Addendum No. 1

RE: Contract ID C203172

US-17 From Chowan River To Perquimans County and 2 Sections
Of Secondary Roads

September 18, 2012 Letting

PROJECT REFERENCE NO.	SHEET NO.
1CR.10211.8, ETC.	4A

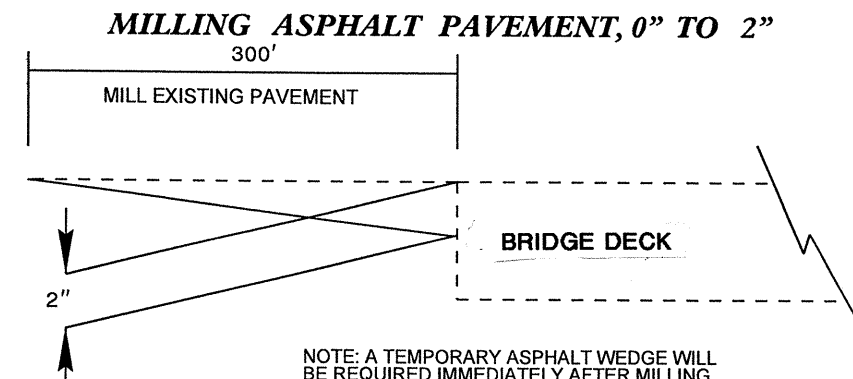
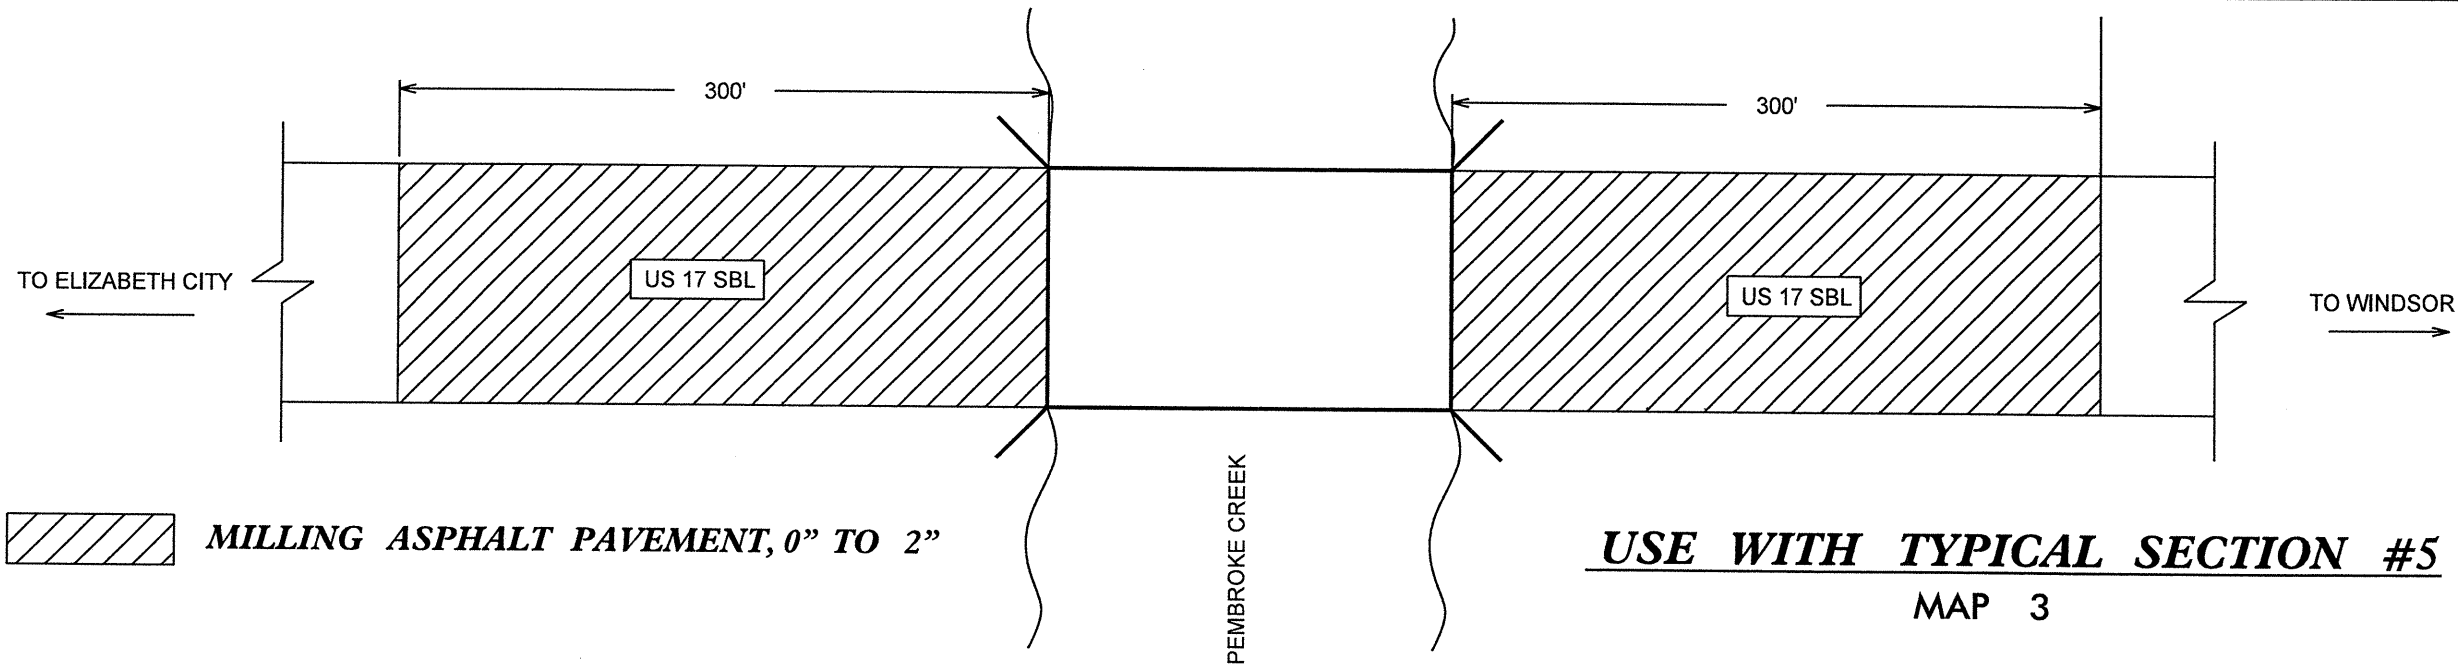
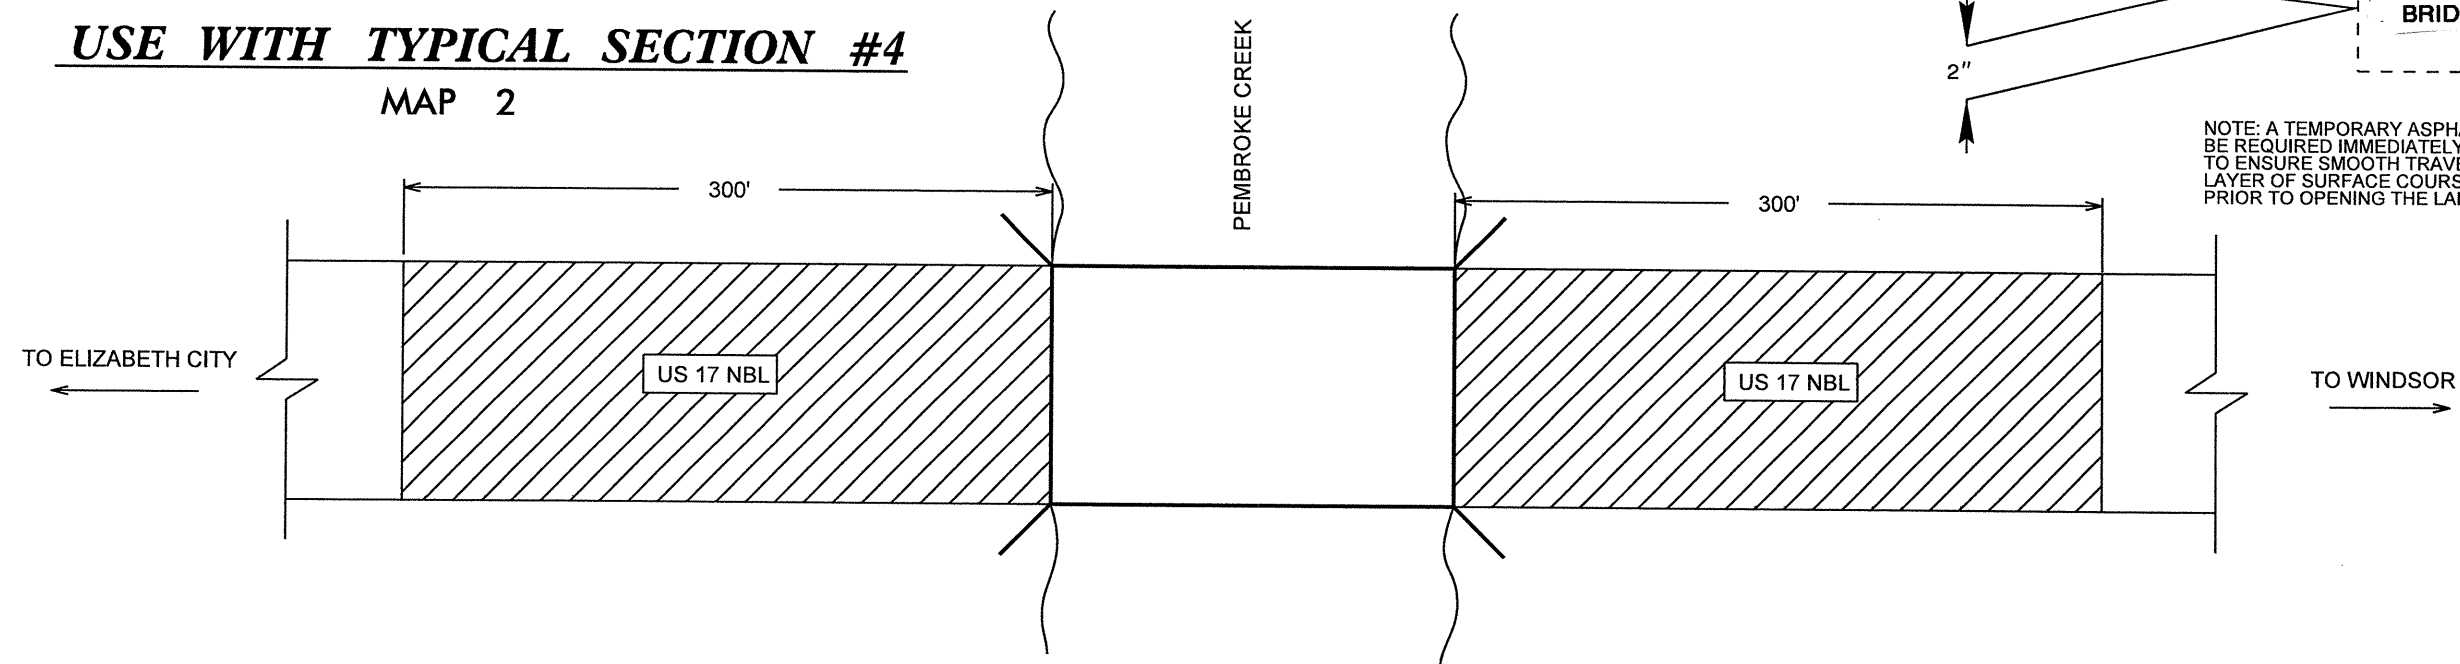
New Sheet No. 4A has been added to include a detail for variable depth milling at bridge approaches. Please staple new Sheet No. 4A after Sheet No. 4 in your plans.
